Final Report - Corrections Required **Application No. ANEX-24-0003**

Description : Matrix Design Group on behalf of Colorado Springs Equities LLC is submitting a serial annexation petition for seven parcels and Land Use Plan/Rezoning exhibit for a portion of the subdivision known as Rock Creek Mesa.

Document Filename : Rock Creek Mesa Addition No 2 _Annexation Plat_V3_5-13-24

# ANNEXATION PLAT ROCK CREEK MESA ADDITION NO. 2

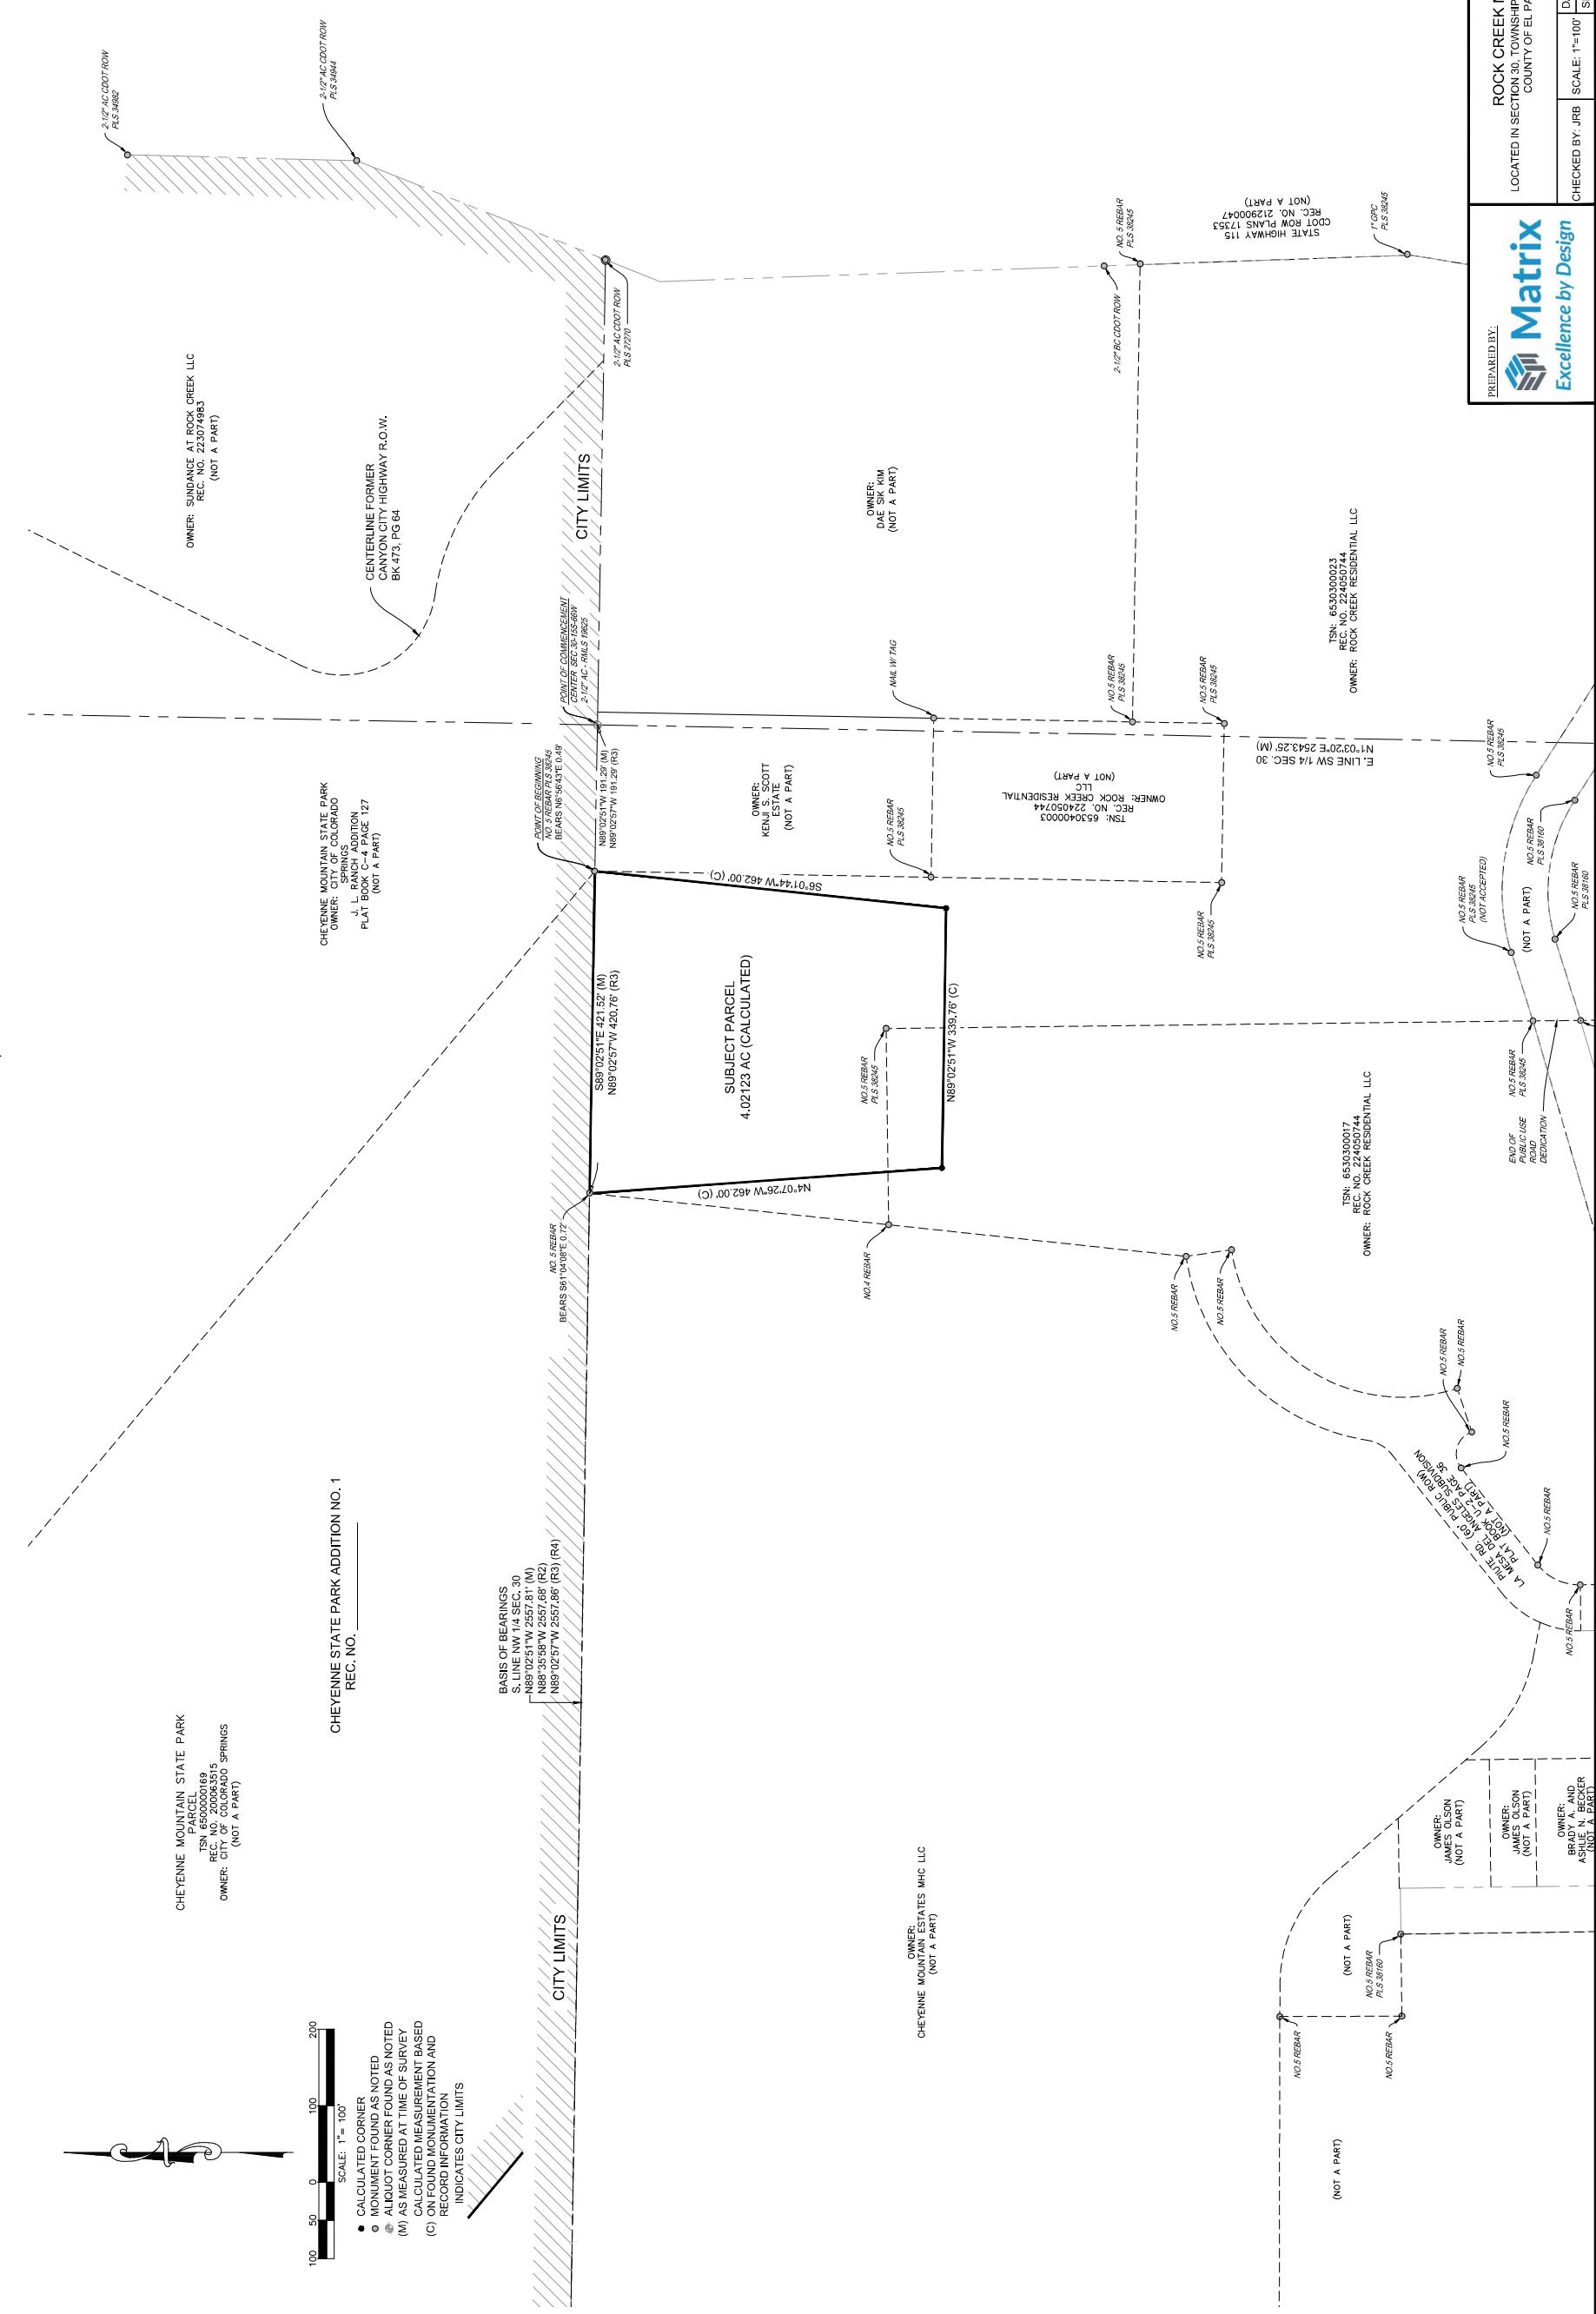
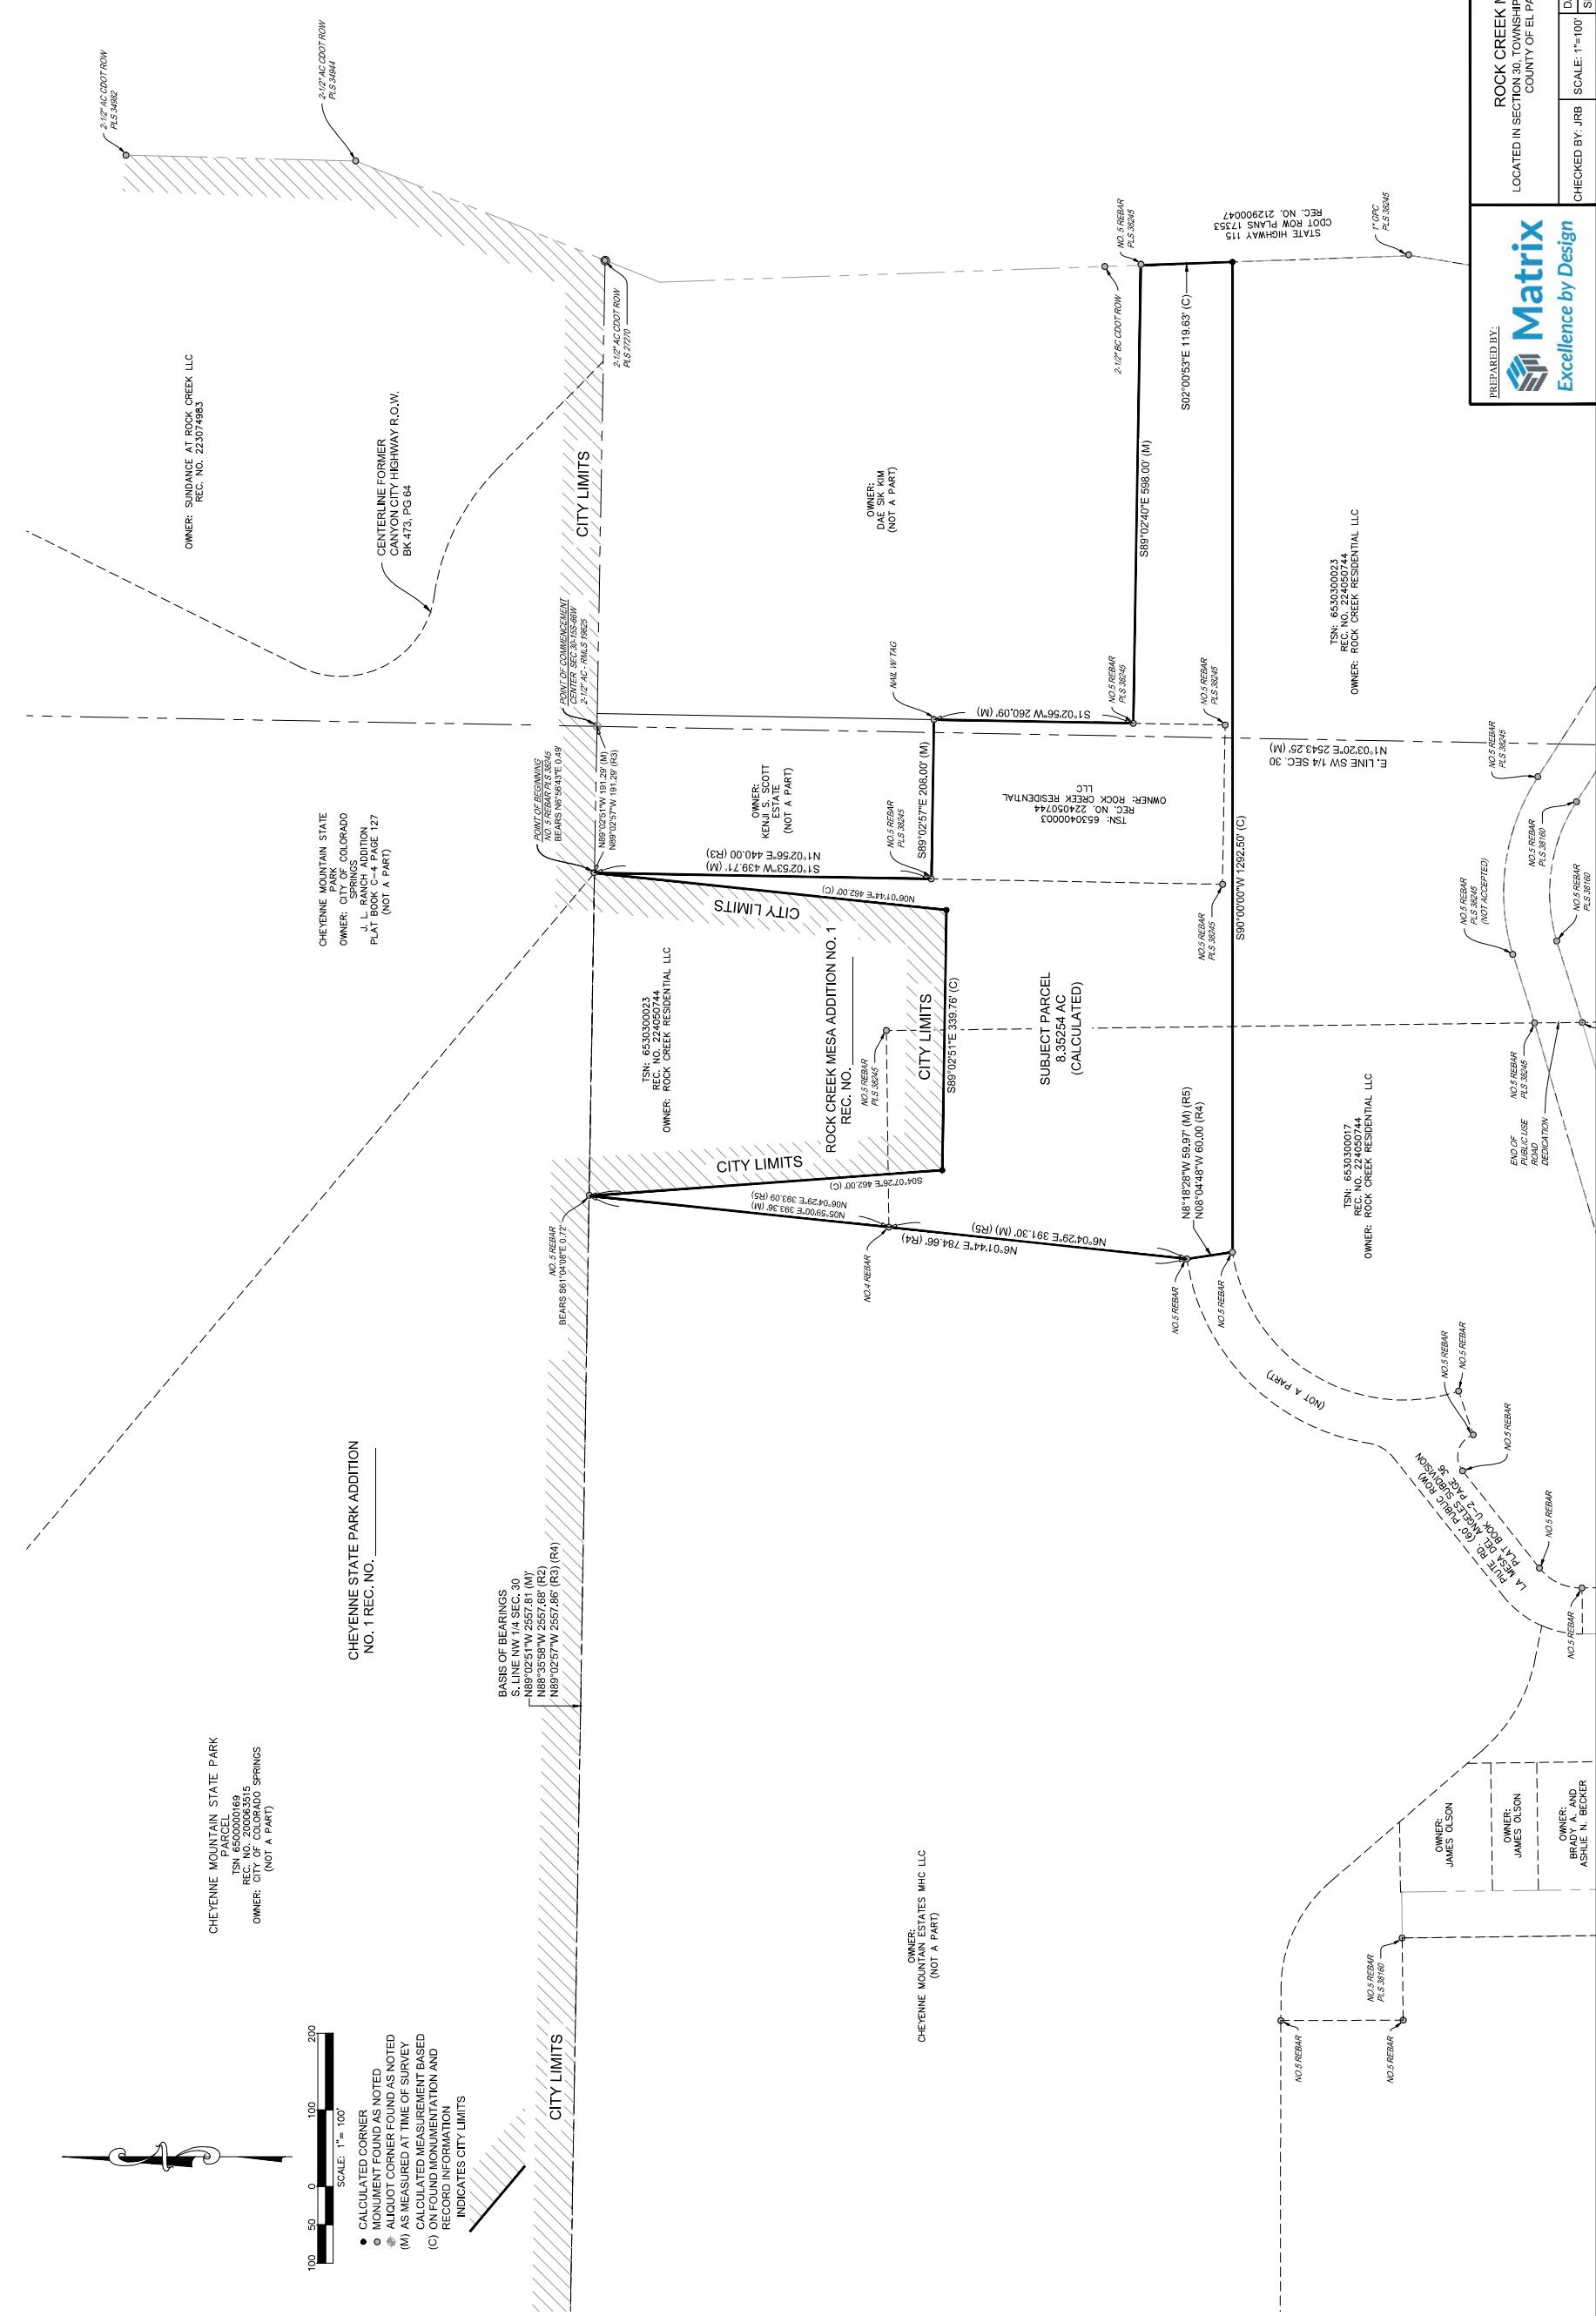
Comment ID	Page Reference	Reviewer : Department	Review Comments
36	2	Matthew Alcuran : Col Springs Utilities	Please add a general note to confirm the establishment of an appropriate easement(s) through a final plat for the existing OH electric (12.5kV Primary OH Conductor: CSU #12JL-1) running through portions of Addition Nos. 3, 5 and 6 or if it is to be relocated as part of the proposed future development.
38	1	Cory Sharp : Planning	please determine the name and title of the person signing and complete under owner and notary (so we are not waiting till the end and it be overlooked)
39	1	Gabe Sevigny : Planning	Following Comment if from the School District: We only have one concern which is whether the developer is able to donate any land for an elementary school. 400 homes could generate 600 students - with approx. 350 elementary students and 250 secondary students. The existing schools on Fort Carson do not have the capacity to absorb that many elementary students. We typically need 12 acres or so for an elementary school. We may also need to add a preschool too. (Contact: Vergunst, Joanne jvergunst@FFC8.org) Note from Planner, this will need to be resolved prior to public hearing

37	2	Cory Sharp : Planning	please add a label for this line, centerline former Canyon City Highway R.O.W. Book 473 at Page 64, per other drawings
